City of Albuquerque

RE: REVISED DRAINAGE PLAN FOR KENTUCKY FRIED CHICKEN
(L-22/D41A1) ENGINEER'S STAMP DATED JUNE 6, 1990

RE: DRAINAGE PLAN FOR KENTUCKY FRIED CHICKEN
(L-22/D41A1) RECEIVED JUNE 20, 1990

GRADING AND DRAINAGE PLAN SCALE: 1"=20.0'

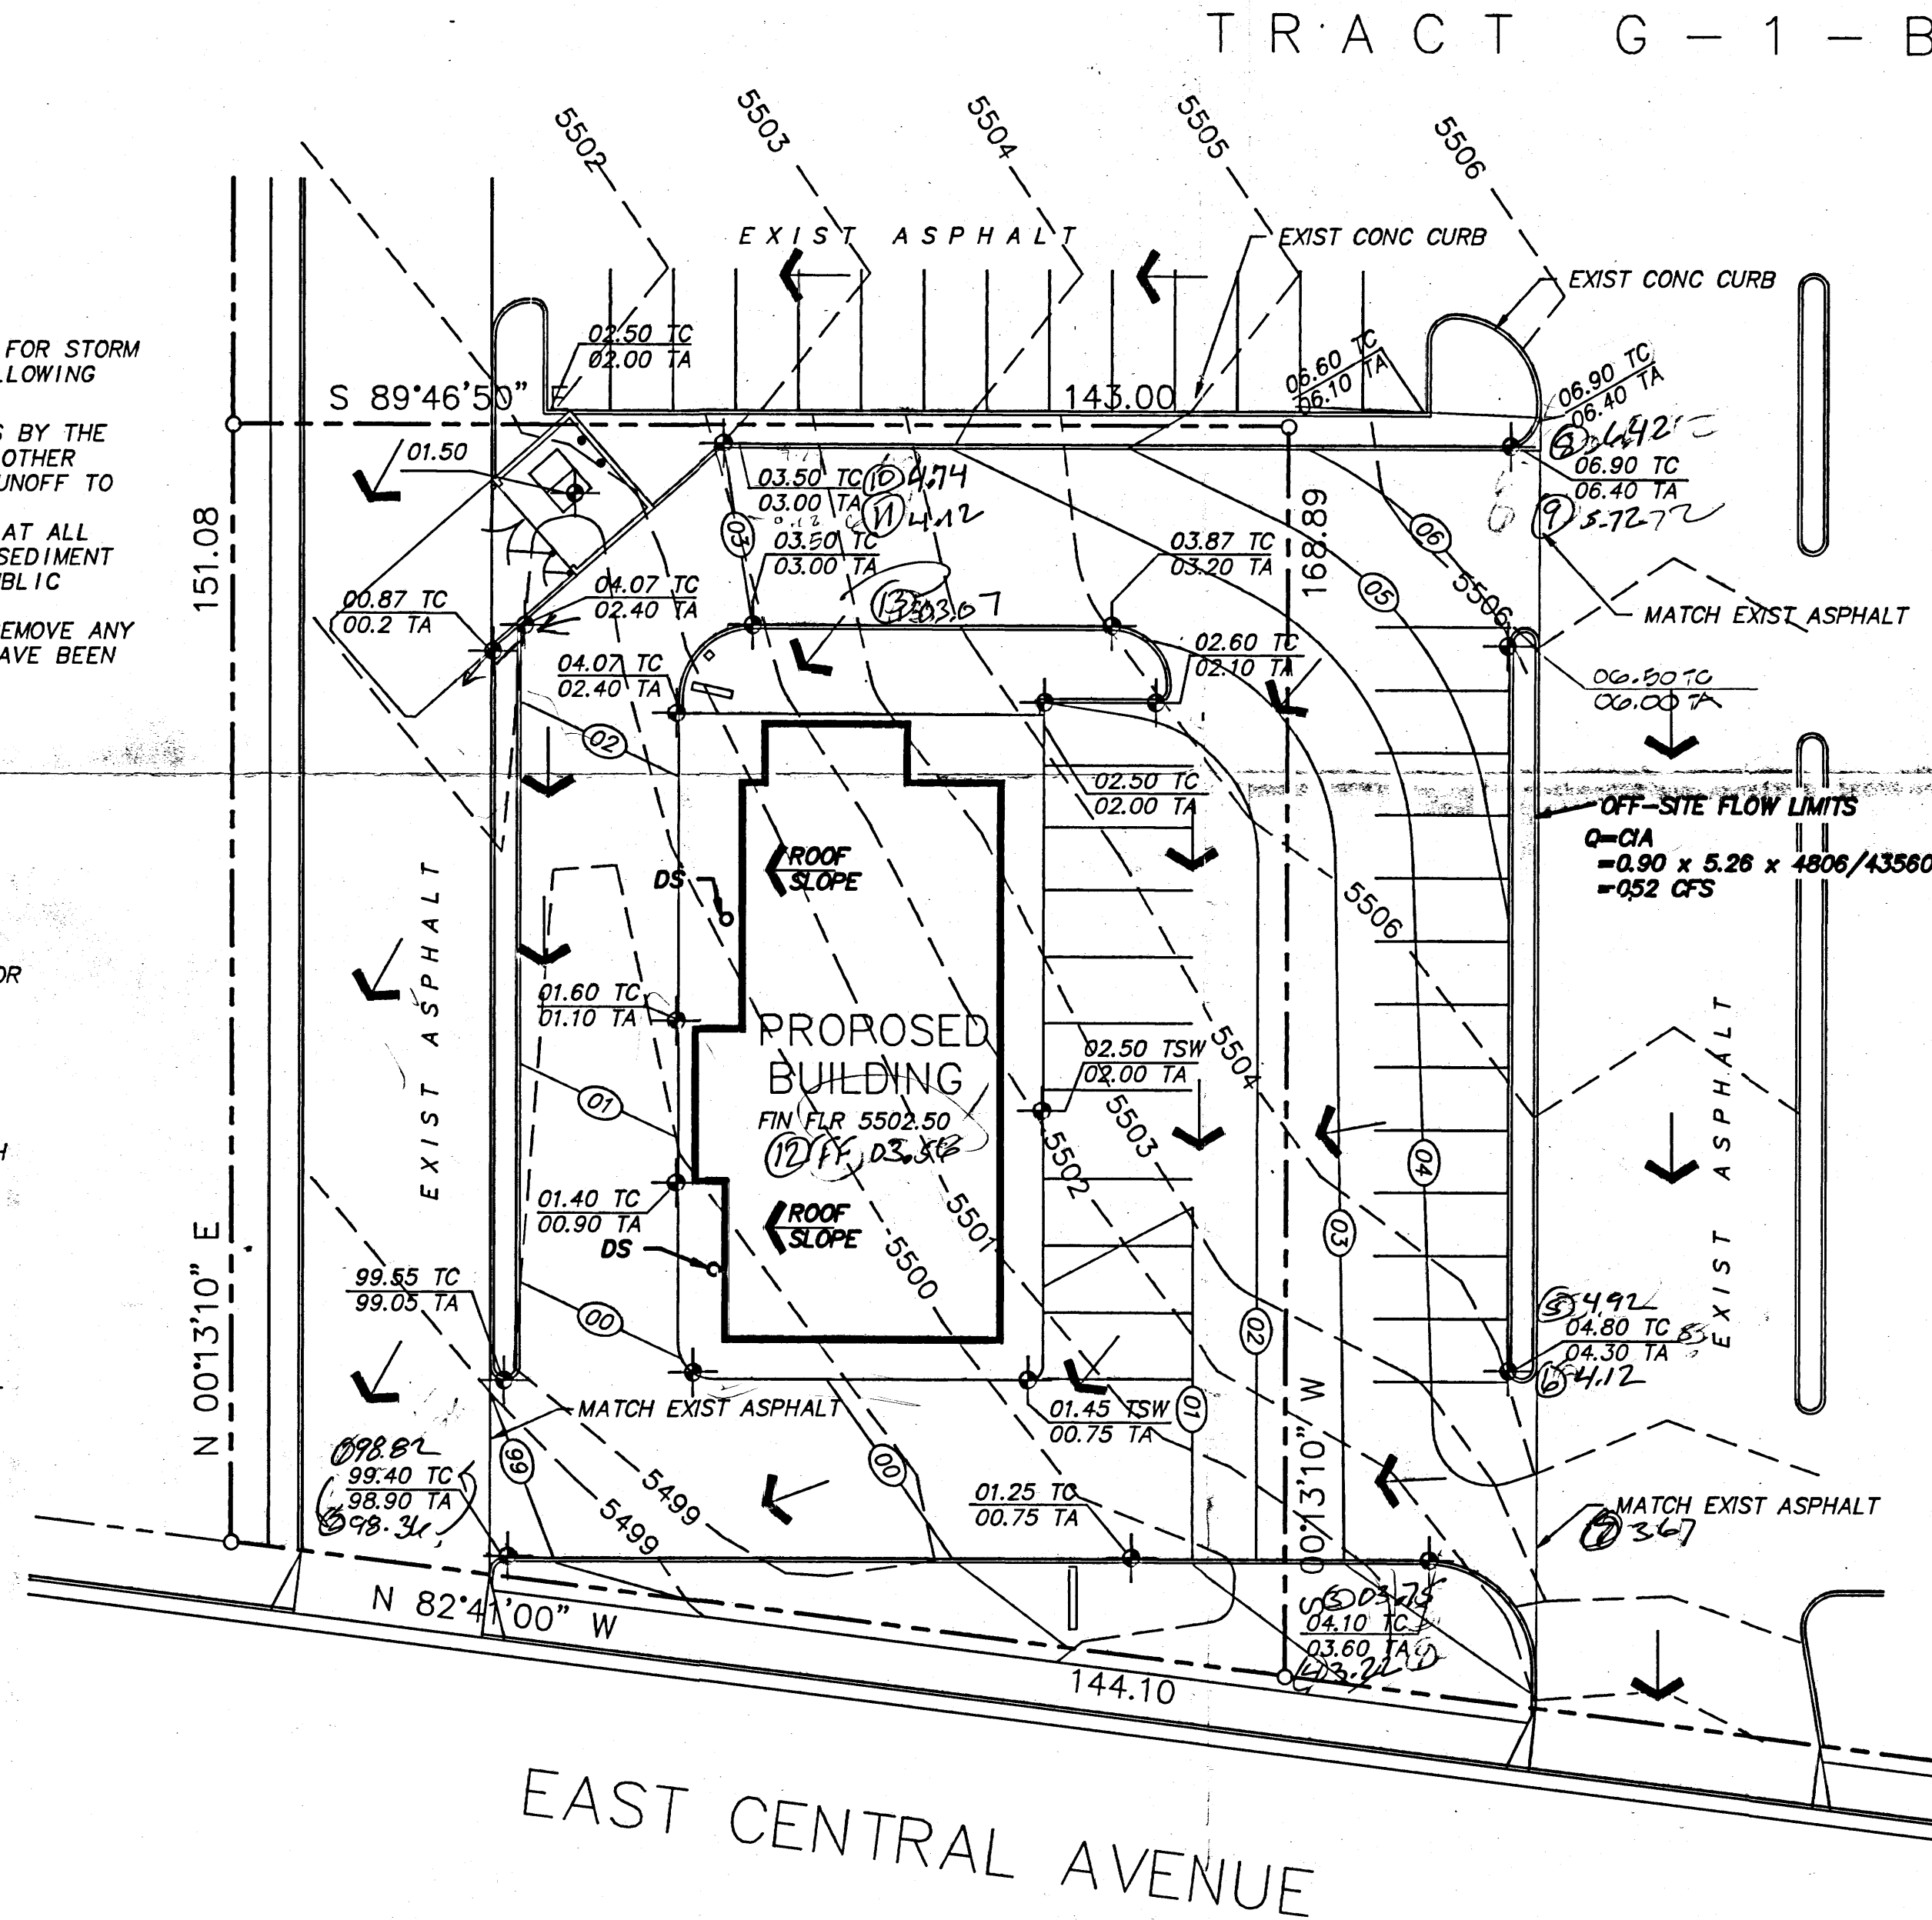
1. Provide our office with a copy of the filed replat for Tract G-1.
2. Your plan drawing indicates that you are proposing construction outside the property limits. Concurrence from the adjacent owner must be provided.
3. Your information sheet for your resubmittal must indicate Building Permit approval also.
4. Engineer's stamp must be dated with the resubmittal date.

There will be a Kentucky Fried Chicken building to be built on Tract G-1-A as shown on the plat of said property, of which our firm is an owner. In addition, we are an owner in Tract G-1-B and realize that some of the parking lot improvements will overlap on to the latter tract.

There is also a reciprocal access, parking, drainage and utility easements for all three (3) parcels to include the two above and Tract G-1-C; such is stated on the recorded plat.
